Re: 20-6461-A
GARY ROBINSON-STOCKTON XL-SOUTH CREEK#44 ROOF

The truss drawing(s) referenced below have been prepared by Truss Engineering Co. under my direct supervision based on the parameters provided by Riverside Roof Truss.

Job	Truss	Truss Type	Qty	Ply	GARY ROBINSON-STOCKTON XL-SOUTH CREEK#44 ROOF	147373489
20-6461-A	F03	FLOOR GIRDER	1	1	1 UNIT JTE

Job	Truss	Truss Type	Qty	Ply	GARY ROBINSON-STOCKTON XL-SOUTH CREEK#44 ROOF
20-6461-A	F03	Floor Girder	1	1	Job Reference (optional)

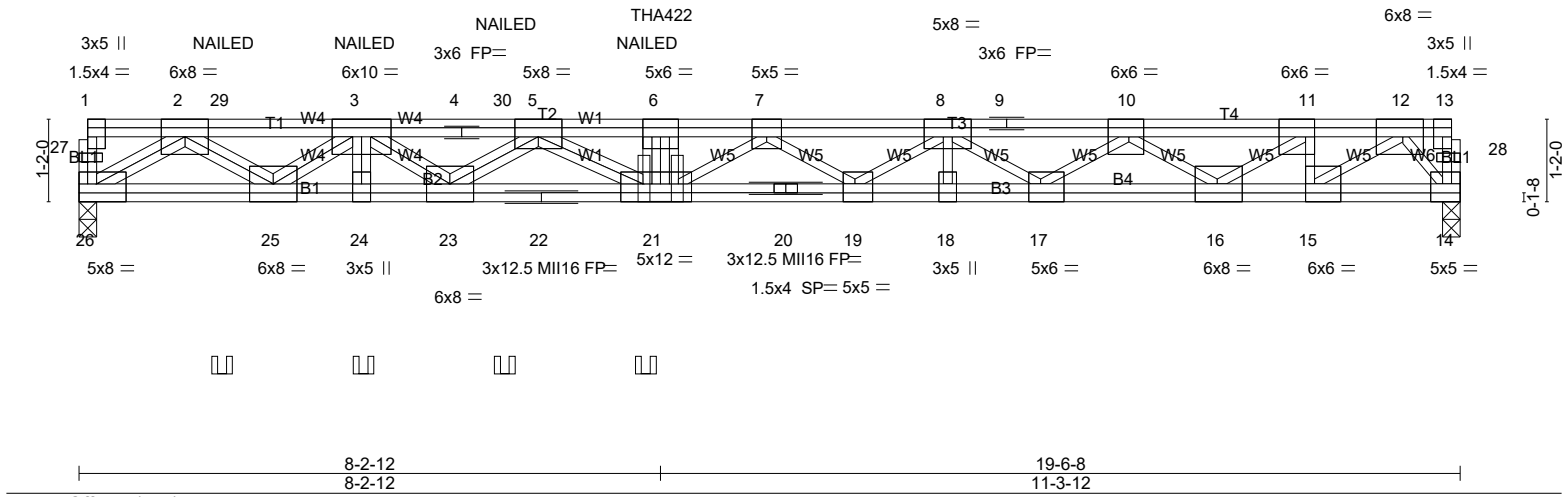
REPAIR: TRUSS WAS INSTALLED BACKWARDS AS SHOWN.
